From: Ian Sellar [REDACTED]
Sent: 06 January 2021 14:44
To: Simon Davis <Simon.Davis@arun.gov.uk>
Subject: RE: Y/140/20/DOC - Cinders Lane Nursery and works to the rear, Cinders Lane, Yapton, BN18 0JJ

Subject: Y/140/20/DOC - Cinders Lane Nursery and works to the rear, Cinders Lane, Yapton, BN18 0JJ

Scale : 1:500 @ A1 Date : SEPT 2020
Drawing No : 97_17_103

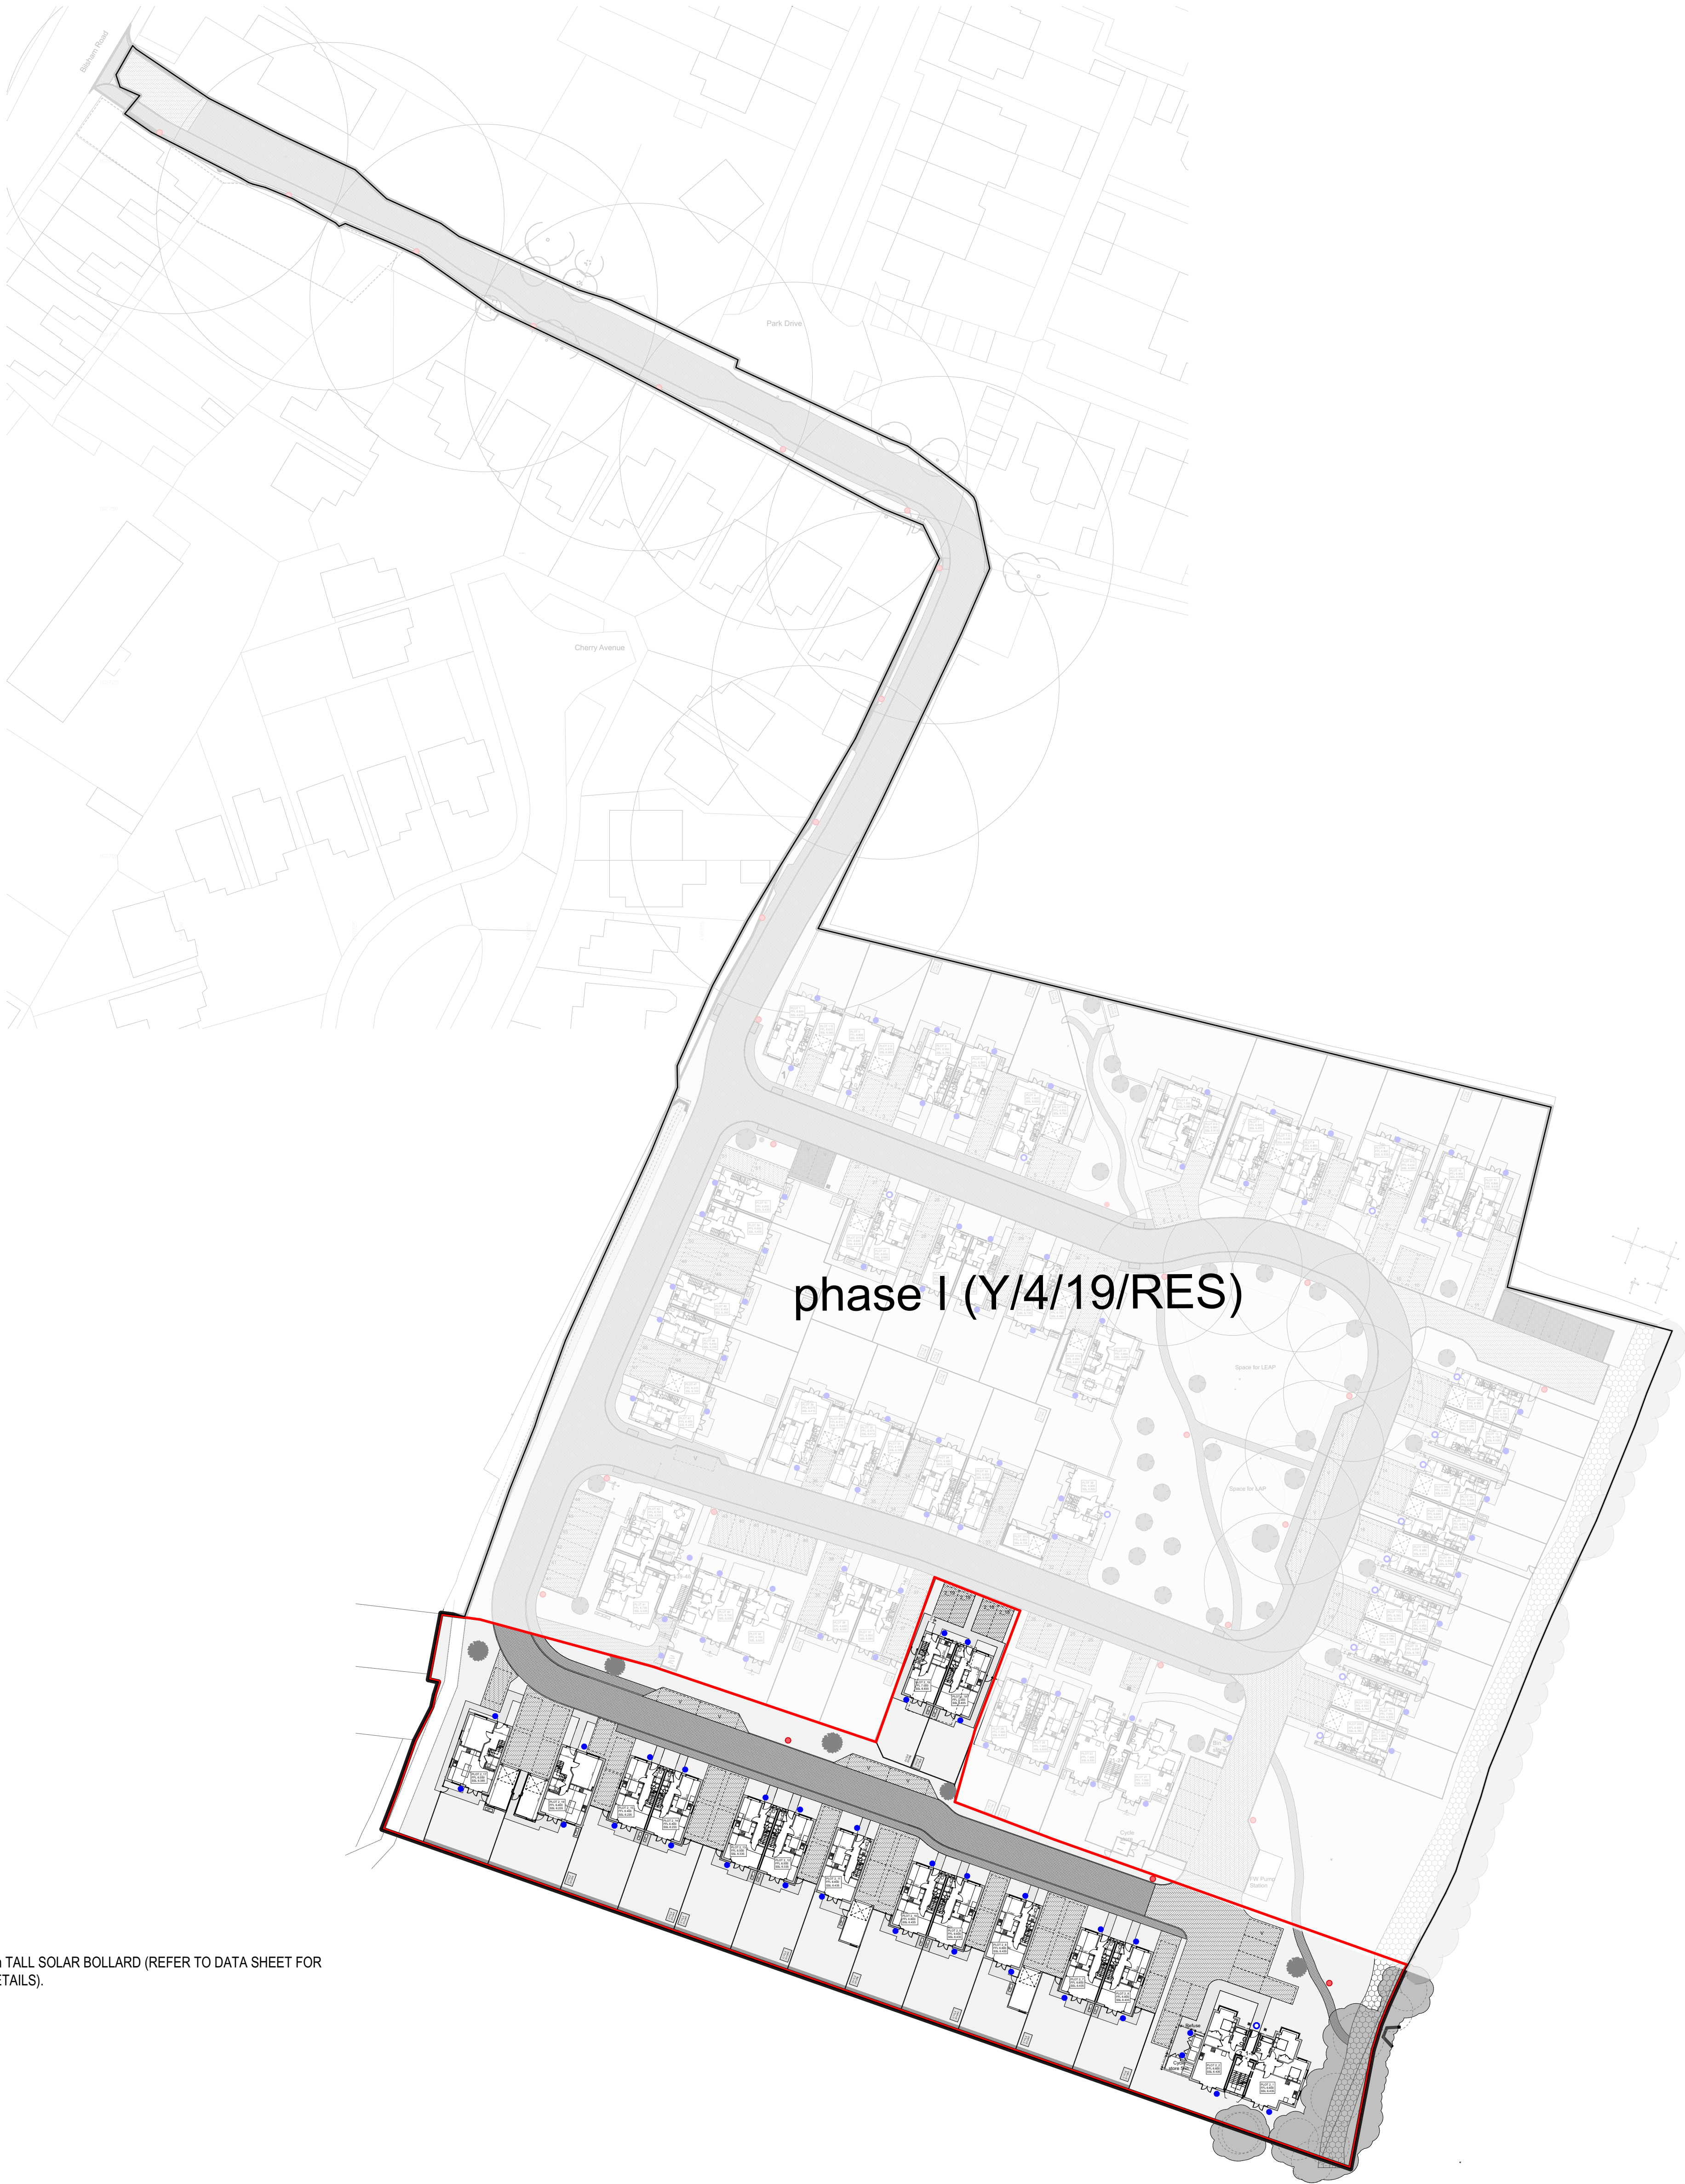
With regard to the discharge of condition 19 (lighting), the external lighting plan and light detail sheets should please be updated to include detail the light spill from each installation point. Please also note that EH cannot comment on the potential impact on bats in the vicinity.
